Your Ref: OWPC23028
Our Ref: M/27/19/NMA 27-03-2019
Please ask for:
Andrew Wood

Non-material amendment following the grant of planning permission reference M/84/18/PL for changes to cladding and brick piers. Raising of roof level following Environment Agency advice.

Ohana 24 Alleyne Way Elmer Middleton-On-Sea

PROJECT TITLE Proposed Development at 24 Alleyne Way Bognor Regis	DRAWING TITLE Existing & Proposed Street Scene		No	REVISION	DATE
	STATUS Non material amendment				
	SCALE 1:150	DATE 09.05.2019			
	DRAWN BY	DRAWING No NMA-248-10

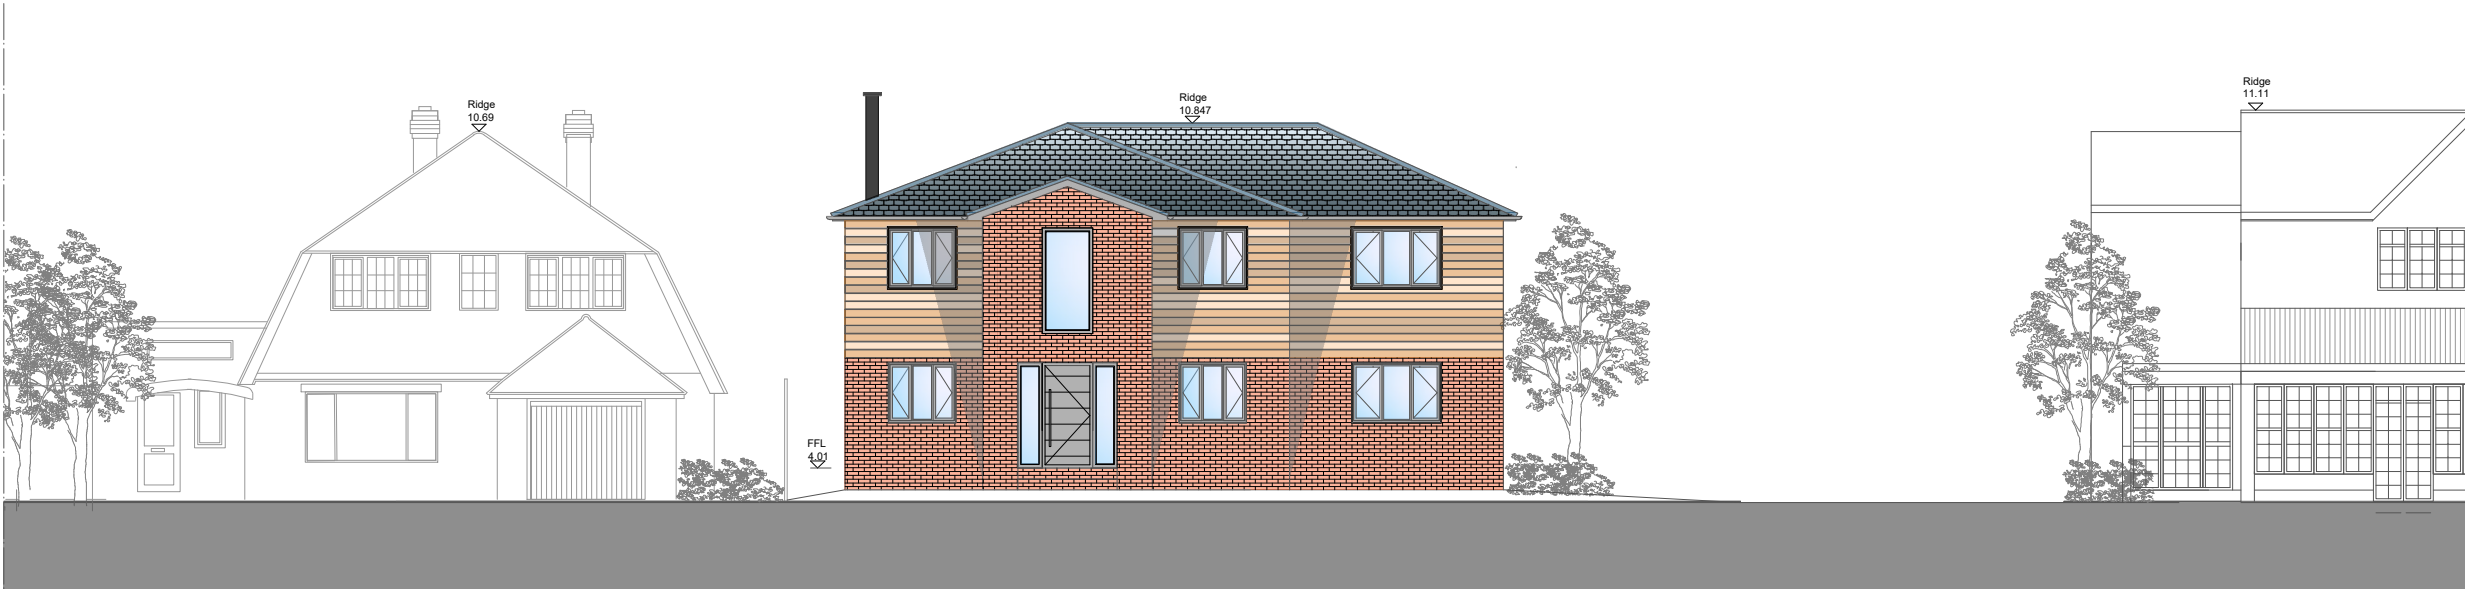
We are pleased that Arun Planning have requested a revised street scene. However, disappointingly, it is still misleading. We are unable to make the scale of 1:150 correspond to the known widths and heights of no.22 and proposed development at no.24. The new development is quoted to be 13m wide and our home is 9.5m wide. A Party Wall Award is in place due to the fact that there is less than 3 metres between the properties. I find it incomprehensible and very disturbing that the architects for no.24 are unable to provide an accurate street scene. Having walked around all the roads in Elmer Sands Estate, the proposed dwelling at no.24 would appear to be the most imposing and out of character with the charm of this seaside setting.
